NSIP Reference Name / Code: TR030007

Title: Natural England's comments in respect of the Immingham Eastern Ro-Ro Terminal Project, promoted by Associated British Ports.

Natural England's Relevant Representations Version 1.2

**Figure 9.9**

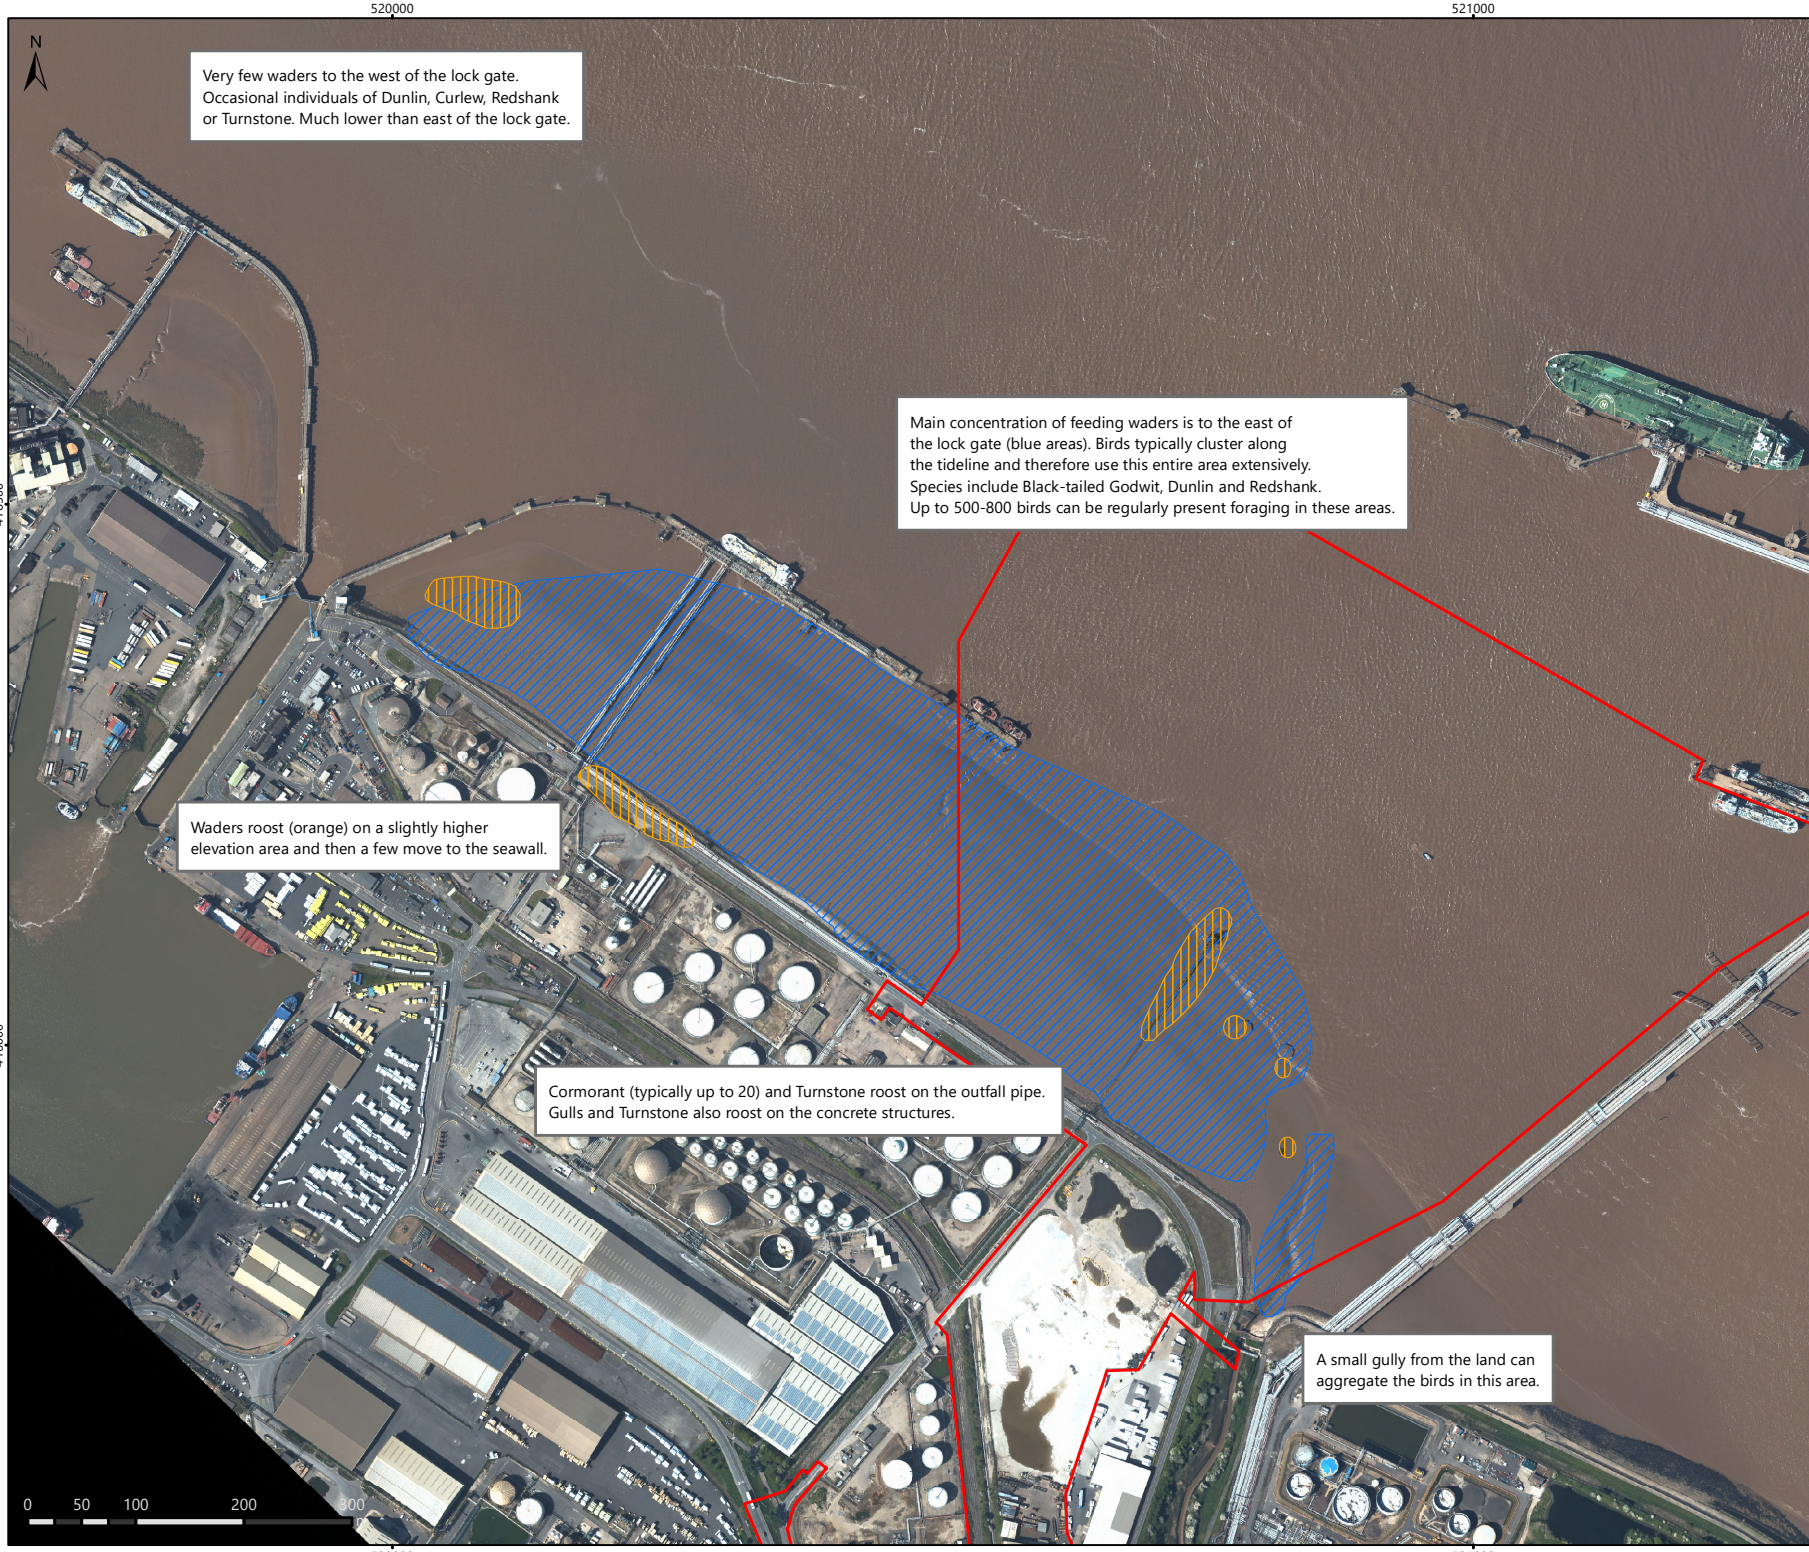
NE key issue ref	Topic	Issue summary (C) – construction phase (O) – operational phase	Natural England commentary and advice on the further information required to enable assessment	Natural England comment on the mechanism for securing mitigation/ compensation measures in the DCO/ deemed marine licence	Risk (RAG)
			<p>from the source are provided. At present, only noise levels at 600m and 1.8km are provided in 4.10.19.</p> <p>The HRA should indicate the expected number of passage and wintering seasons for SPA birds that will be affected by the construction period. It would be helpful if the HRA could set out the expected period of each of the main construction activities (e.g. capital dredge, construction of jetties etc.)</p> <p>Section 4.10.23 (page 221) states that “<i>The near shore environment in the Port of Immingham area is already subject to large numbers of vessel movements...</i>”. We require further definition around the term ‘<i>large numbers</i>’ here, and further information around how this project might add to that figure.</p> <p>Section 4.10.24 (page 221) mentions that there will be less than one week where noise levels are likely to be disturbing. However, detail has not been provided around when this is expected to occur, and whether this is occurring outside of the most sensitive period.</p> <p>Section 4.10.29 states that birds that are disturbed from intertidal areas by construction works can use other areas beyond 200m of works (Figure 9.10 of the ES), or could</p>
